Application Ref:	3/2026/0032				Ribble Valley Borough Council www.ribblevalley.gov.uk	
Date Inspected:	06/02/2026	Site Notice:	06/02/2026			
Officer:	MC					
DELEGATED ITEM FILE REPORT:					APPROVAL

Development Description:	Installation of non-illuminated fascia sign, non-illuminated hanging sign and 2 no. non-illuminated window poster signs
Site Address/Location:	19 - 21 Berry Lane Longridge PR3 3JA

EXTERNALLY ILLUMINATED FASCIA SIGN 'HERITAGE'

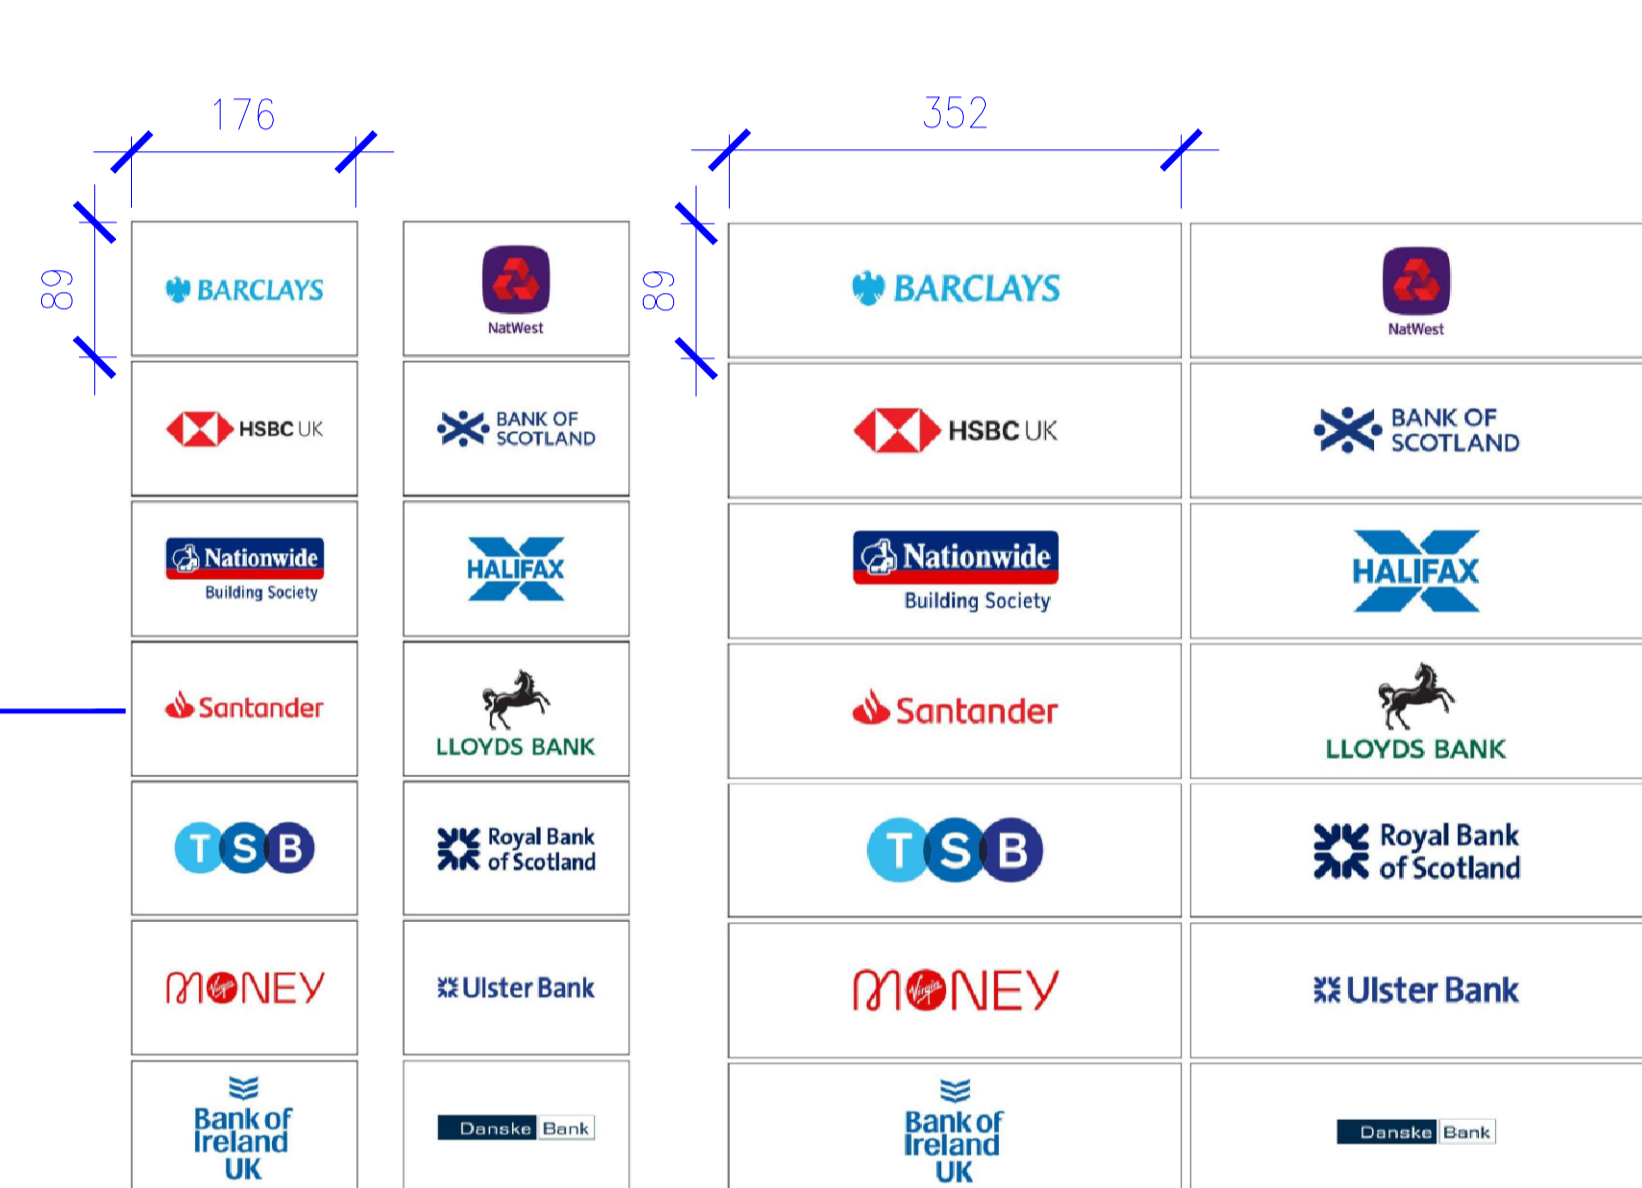
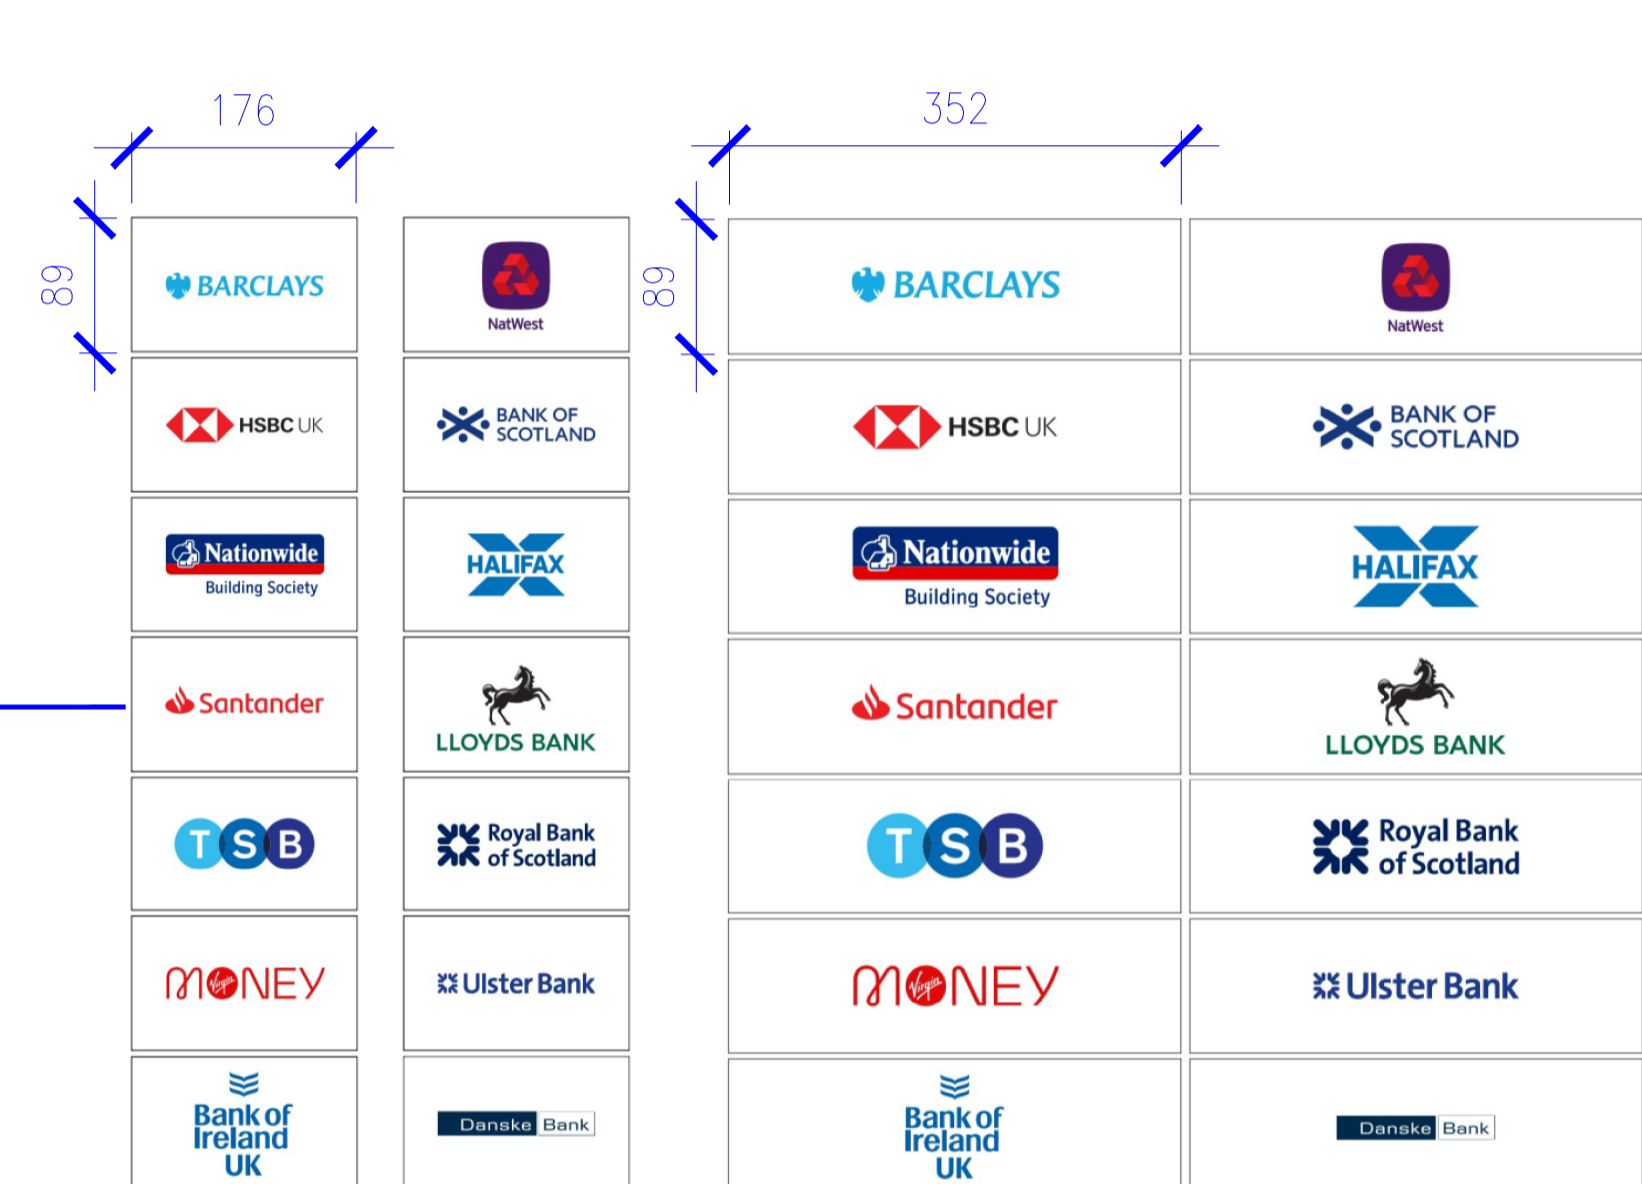
CONSULTATIONS:	Parish/Town Council
Longridge Town Council supports the principle but objects to the proposed illumination which would not be sympathetic to the historic streetscape. The illumination would result in harm to the Longridge Conservation Area and conflicts with the Ribble Valley Core Strategy.

The proposed signage is considered to be acceptable in terms of its size, siting and external materials of construction. The signage would no longer be illuminated which is considered to be more appropriate within the Longridge Conservation Area and the signage would be similar in terms of size, scale and colour to other advertisements within the vicinity of the site.
